**STORM WATER MANAGEMENT PLAN
FOR
NORTHGATE SUBARU
208 AND 309 GLENEAGLE GATE VIEW, COLORADO SPRINGS**

FEBRUARY 2025

County Job No. **TBD** PPR2514
Project No.

DATE: BY: DESCRIPTION:

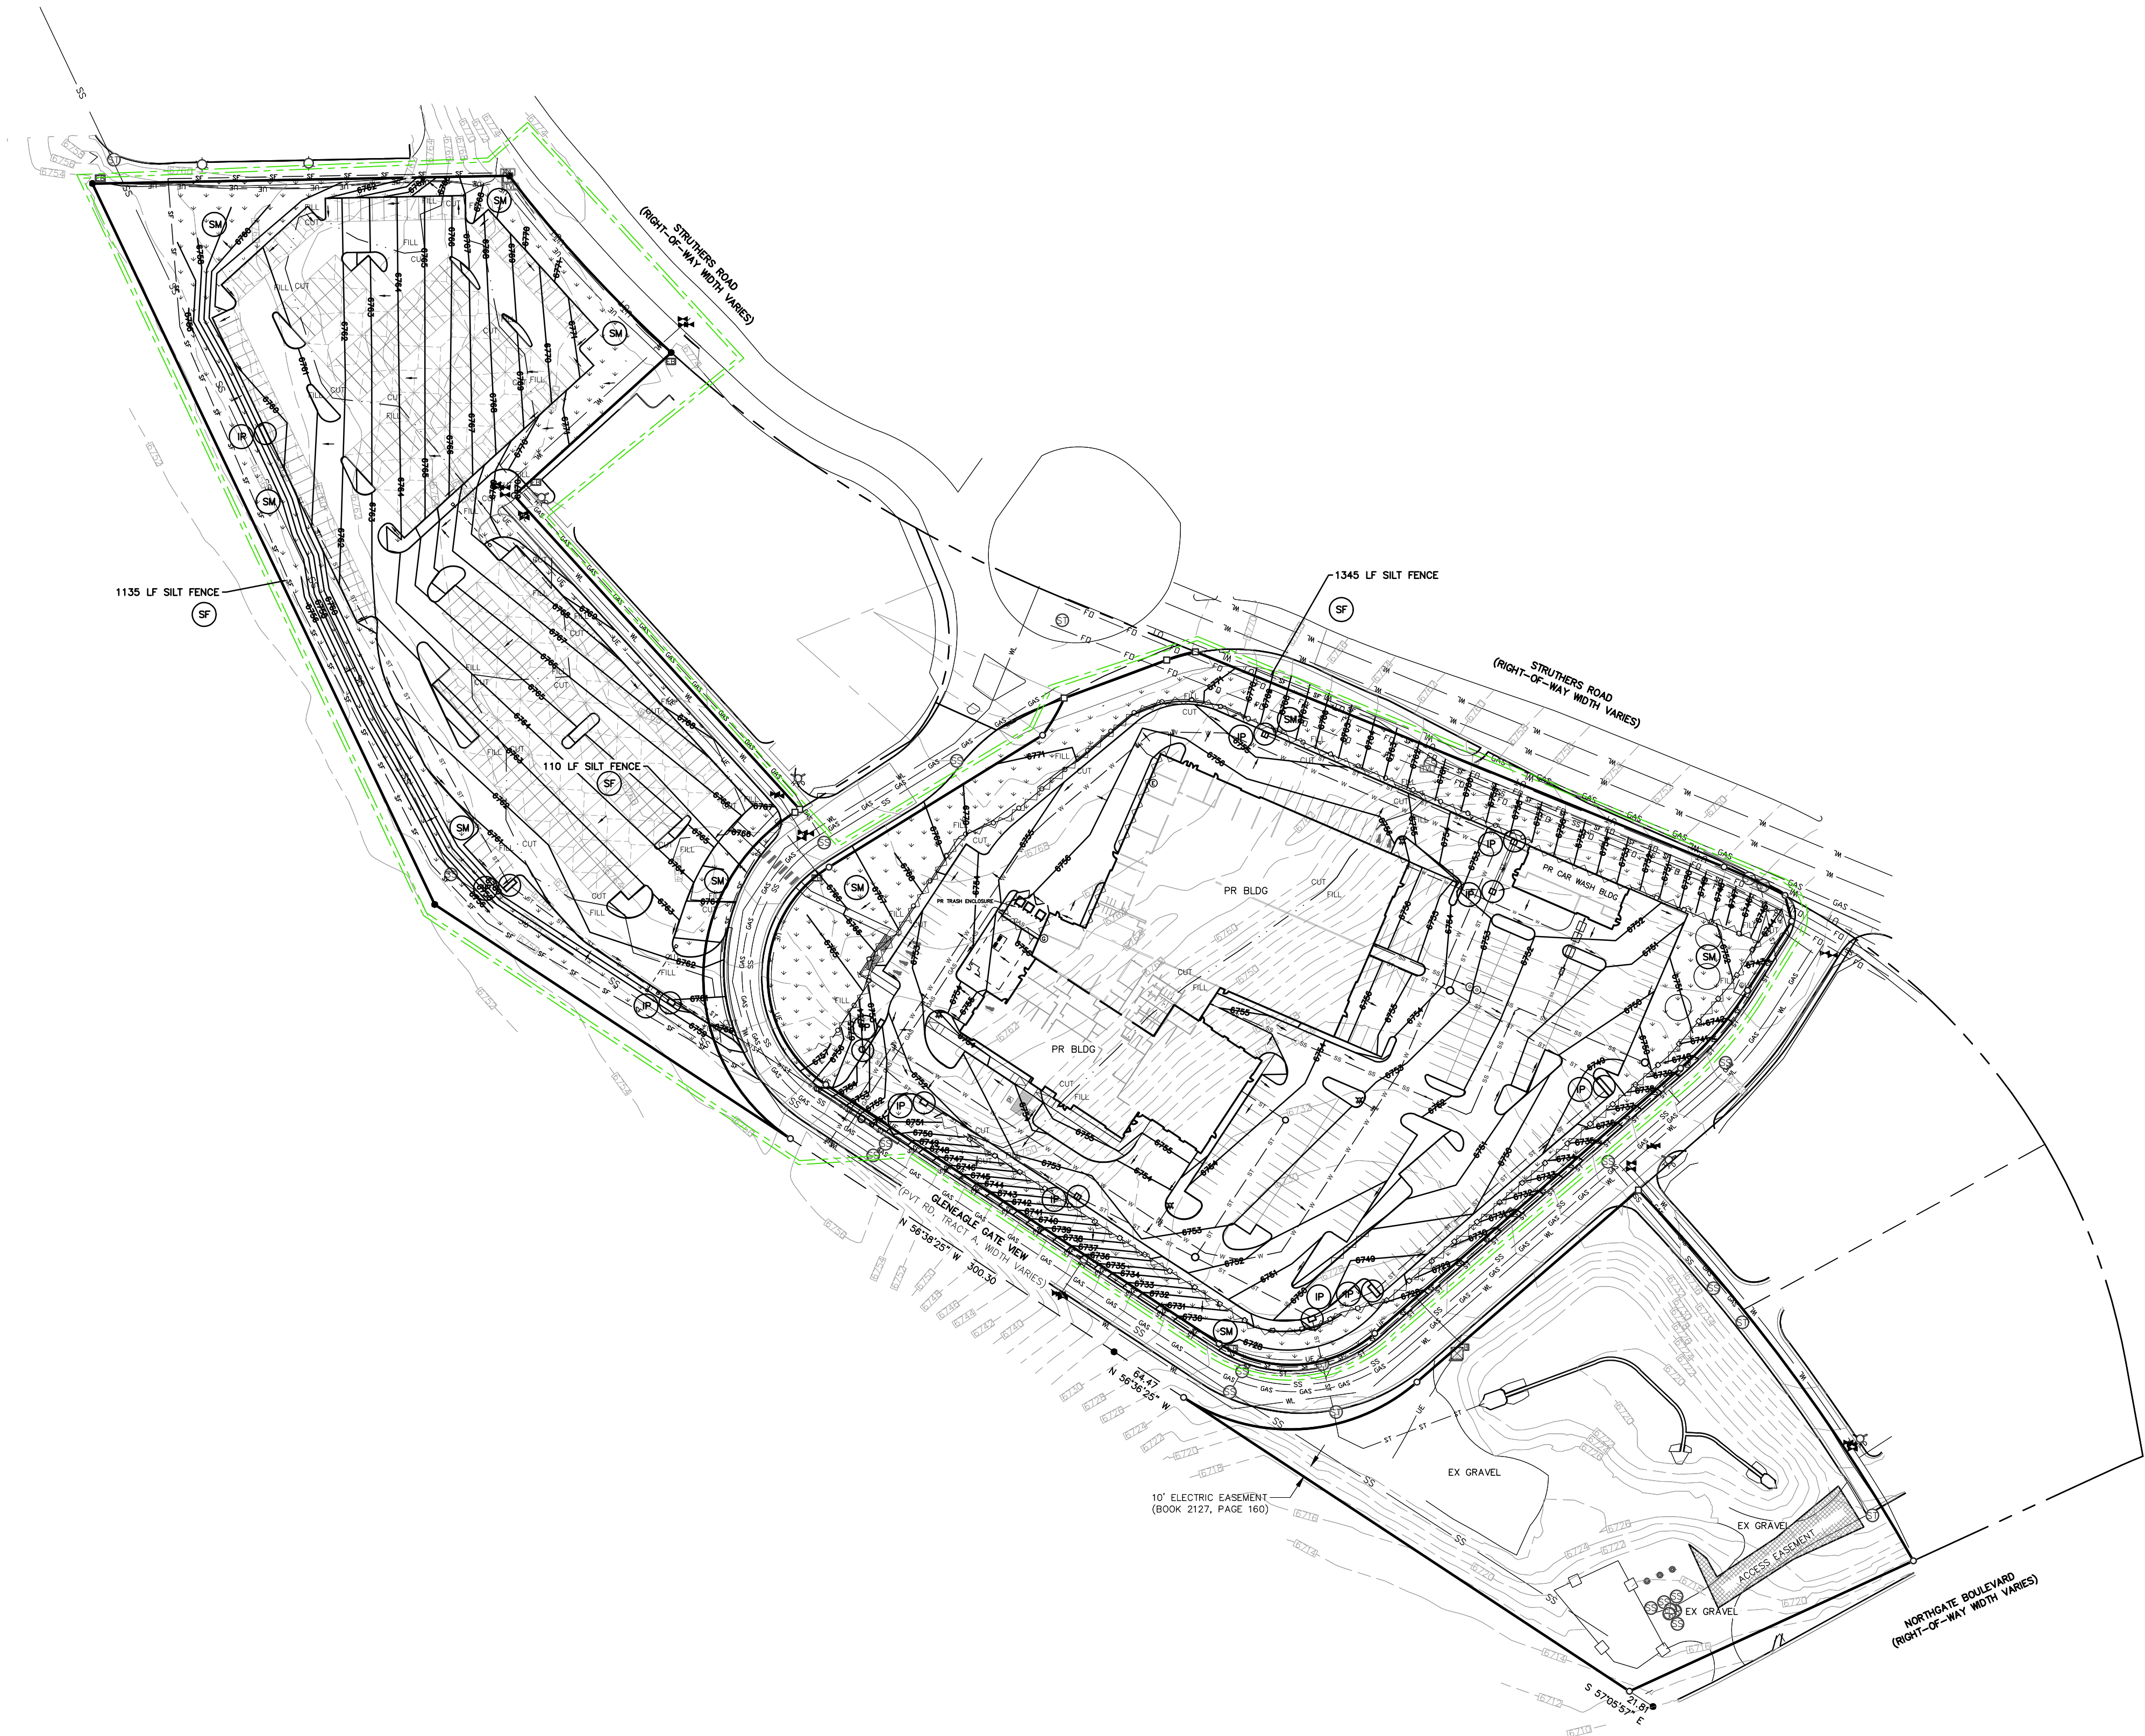
Item 14. Discuss Location and description of any anticipated allowable non-stormwater discharge. Discharge of concrete wash water to ground (e.g. a concrete washout area) is an allowable non-stormwater discharge per the COR400000 Permit if properly identified in the SWMP and if the appropriate control measures are implemented. Revise discussion. Reference COR400000 Part I.A.1.b.ii for more information if needed.
